**Our Case Number: ABP-316119-23**

**Re: DART+ South West Electrified Heavy Railway Order - Hazelhatch & Celbridge Station to Heuston Station, and Hesuton Station to Glasnevin  
County Dublin and County Kildare**

## DART+South West Electrified Heavy Railway Order [2023].

Property Reference 135 (A) (B), DSW. 18832.P.1 (CC) and DSW. 18832.T.1 (CB).

WORKS LAYOUT PLAN
KYLEMORE TO INCHICORE WORKS
SCALE 1:1250 (@A0)

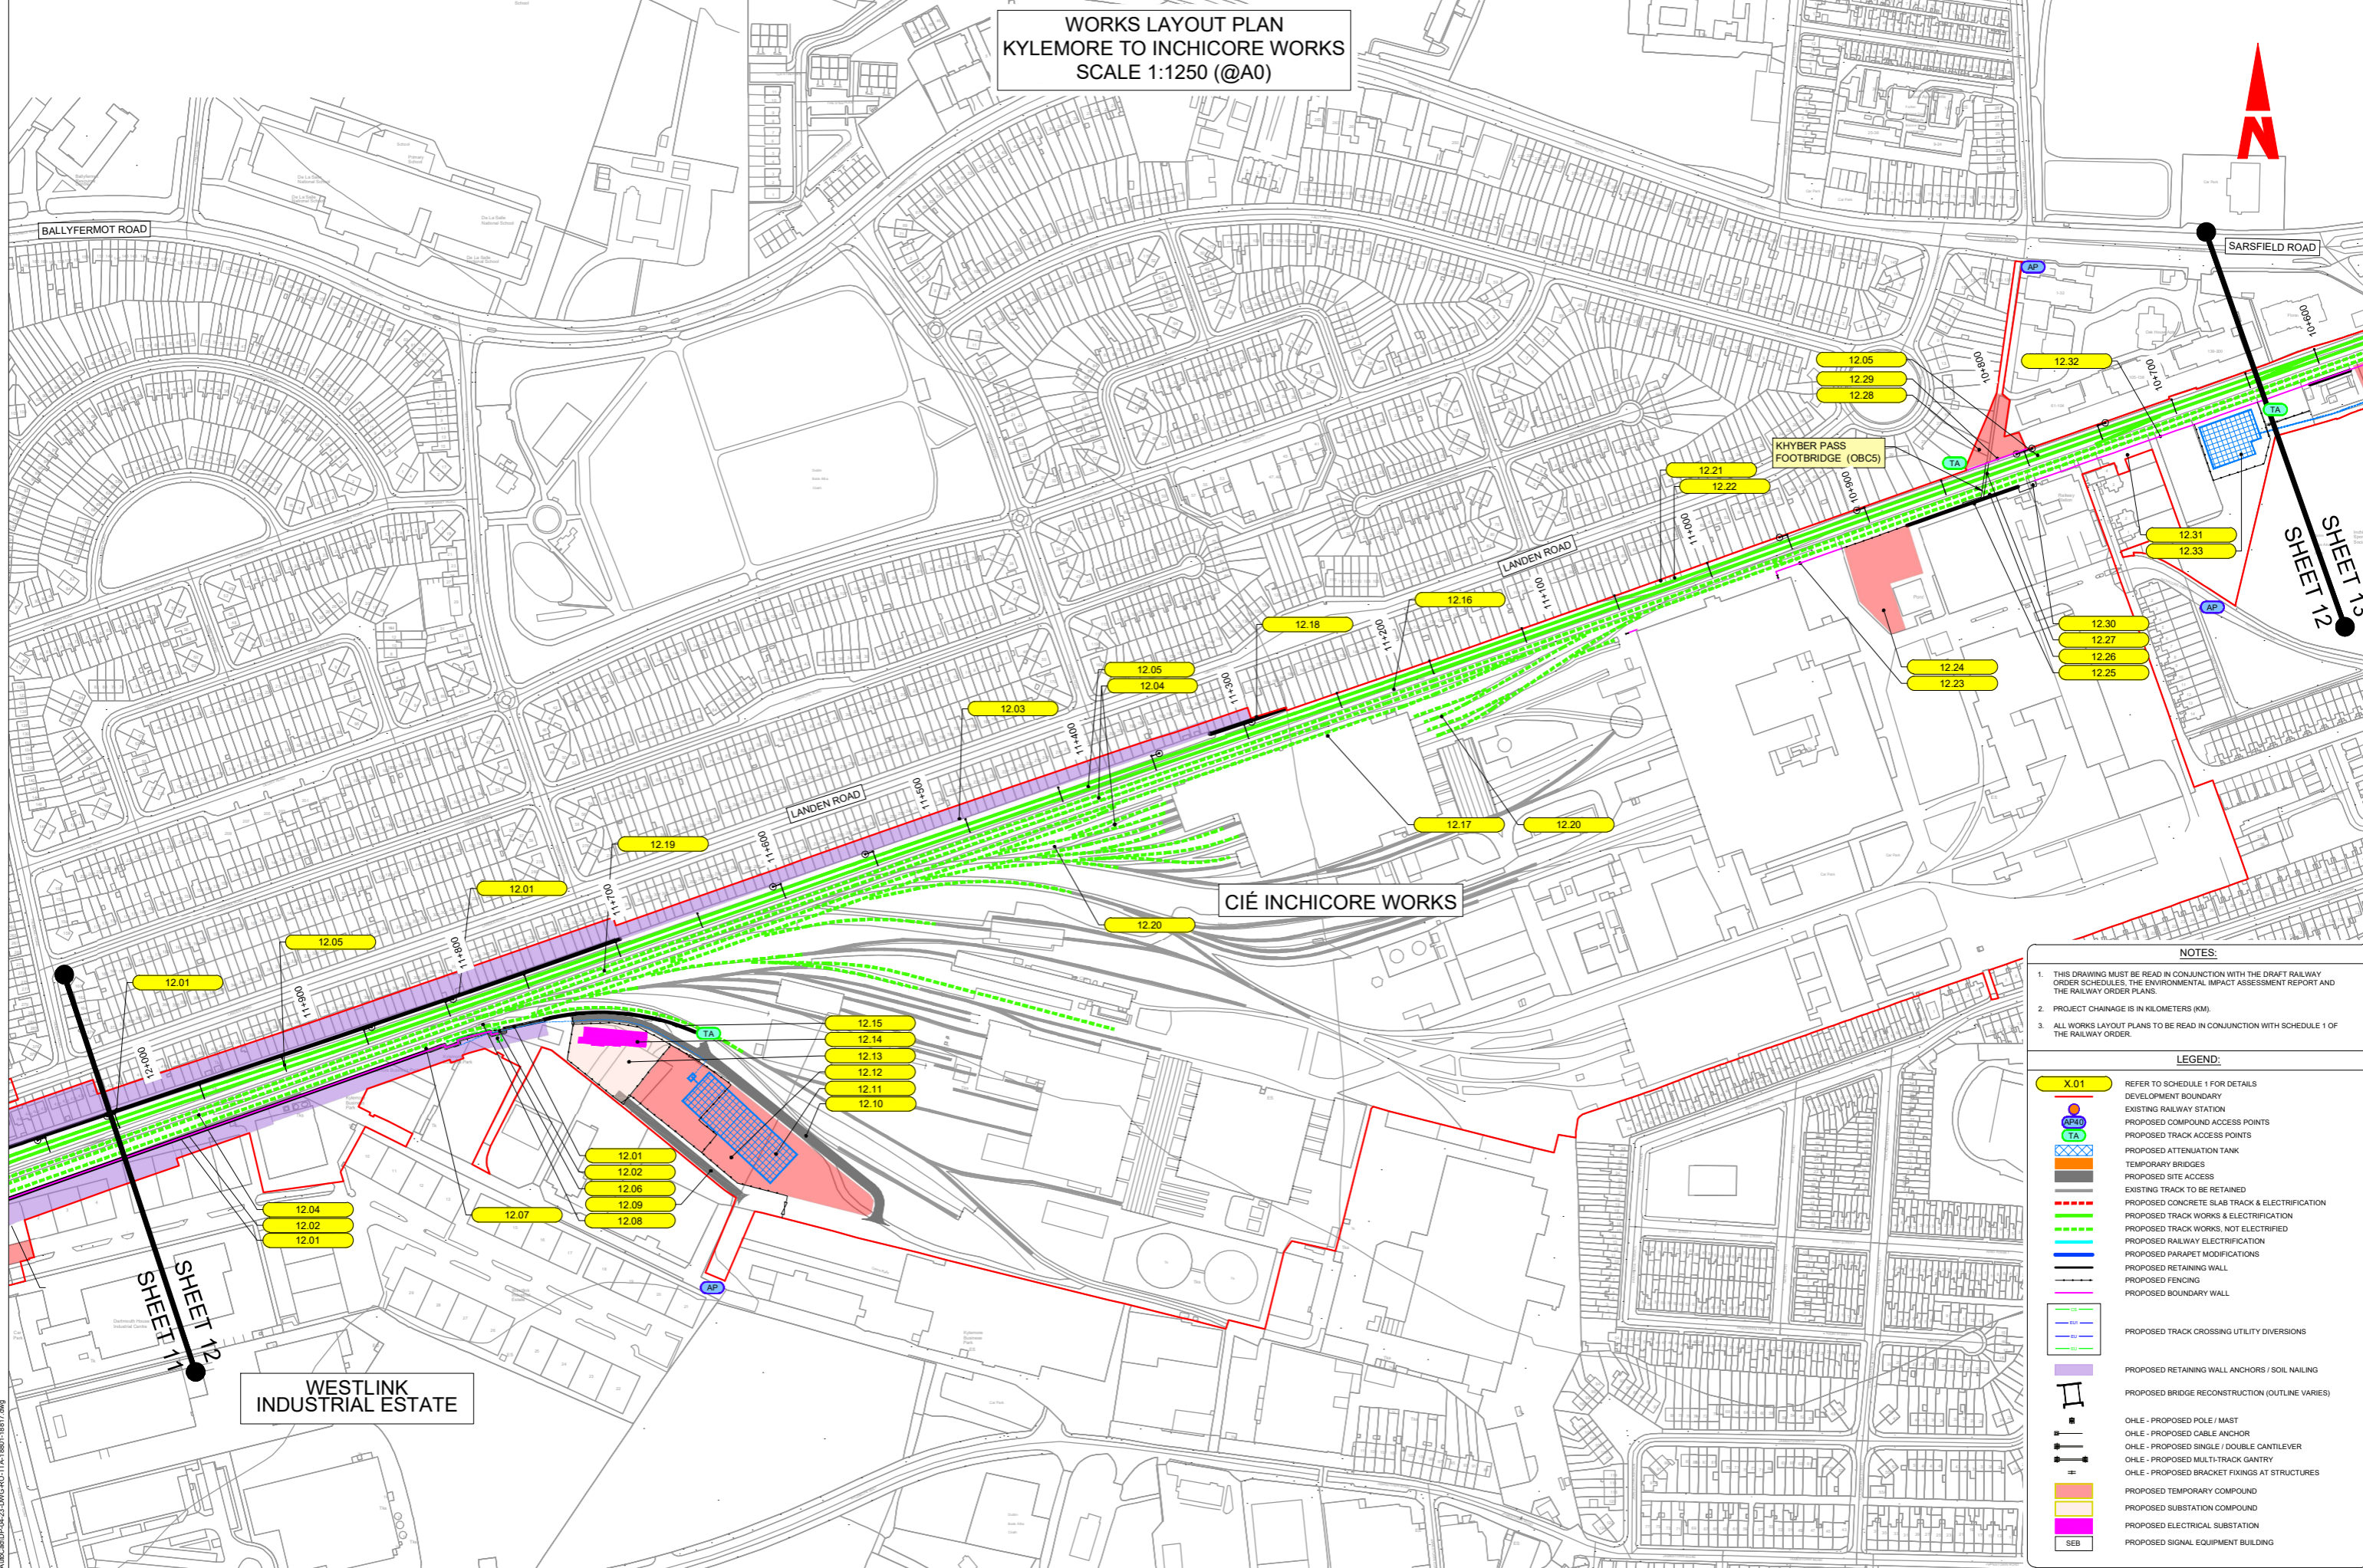
The proposed reconstruction of the bridge, ref. (OBC5) at the Khyber Pass and associated works will impact on my property from a **privacy** point of view. The steps leading to the bridge are currently screened from my property by a line of mature trees at the end of my garden. The proposal to rebuild the bridge with increased height and wider span, and to compulsorily acquire a 24.2 square metres strip of my garden, which is where the trees are growing, for the purpose of widening the Khyber Pass and making a Haul Route for other related works, will require the removal of the trees resulting in the complete loss of privacy.

There is an area of unused ground (ref. 18832 T 302 B) currently wild and overgrown, within the Seven Oaks apartment complex which could be used if the footbridge was re-aligned at a skew.

The proposed widening of the Khyber Pass laneway will involve the removal of the boundary wall and the acquisition of part of my property by Compulsory Purchase Order. The removal of this wall will impact on my property from a **security** aspect as it will expose my property and neighbouring properties to potential intruders and trespassers during the demolition and construction stages of the project.

The temporary acquisition of a further 75.2 sq.m. of my property as a construction site for the Khyber Pass footbridge and a haul route for other works related to the DART + South West project will require the removal of the trees which currently provide a privacy and security screen not only from people using the footbridge but also from the Seven Oaks apartment complex. These trees took a long time to grow as will any replacements.
